Our Ref: M/32/20/HH
Your Ref:

Town & Country Planning Act 1990 (as amended)
Town & Country Planning (Development Management Procedure) (England) Order 2015
Application for Planning Permission for Works or Extension to a Dwelling

Development Removal of single-storey utility room and construction of single-storey extension to form utility / shower room.

Location 48 Southdean Close Middleton-On-Sea

Proposed Ground Floor Plan
Scale 1:100

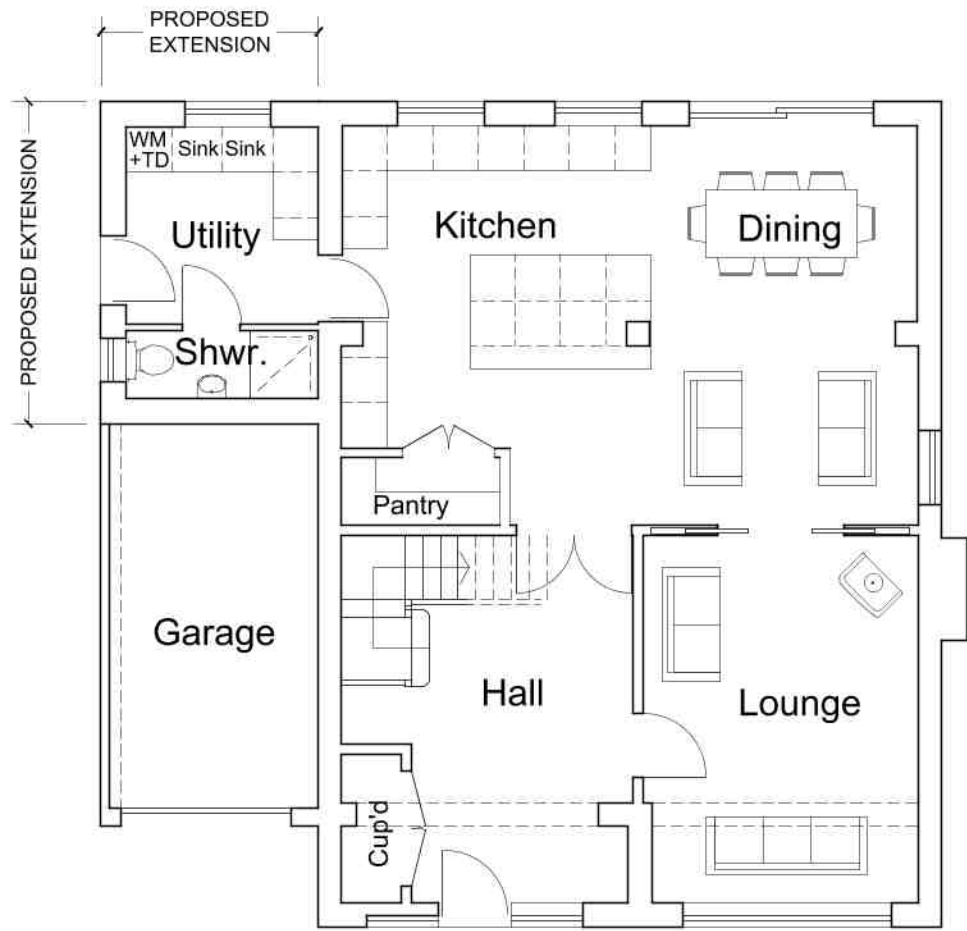
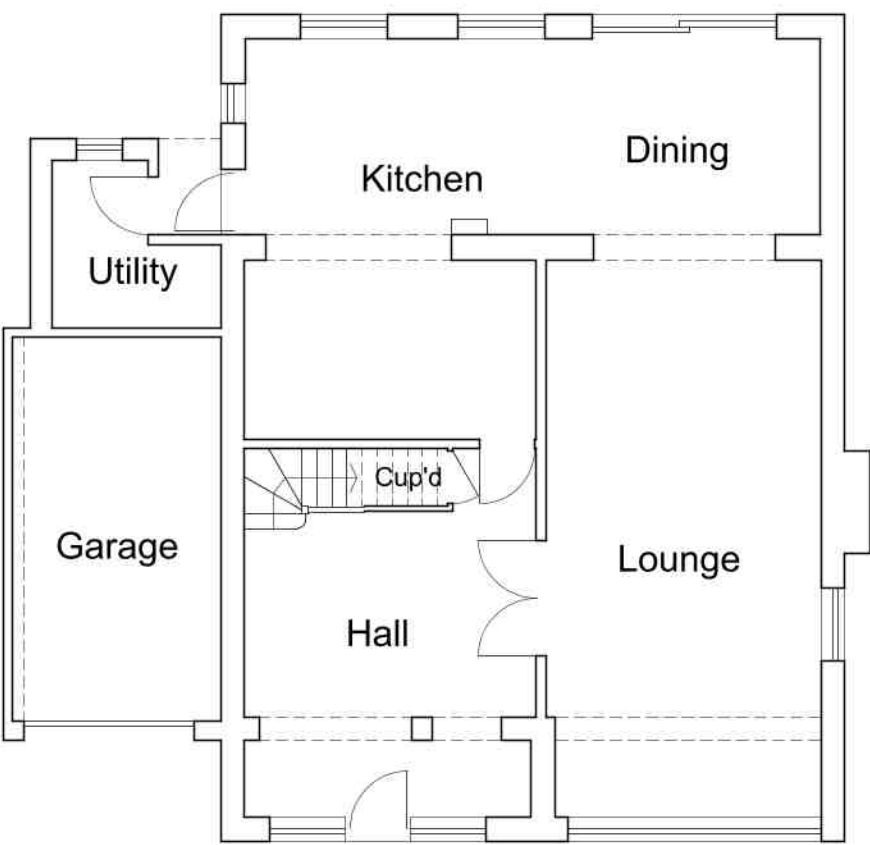
Building Line: The building line is inconsistent between the proposed ground floor and proposed side elevation
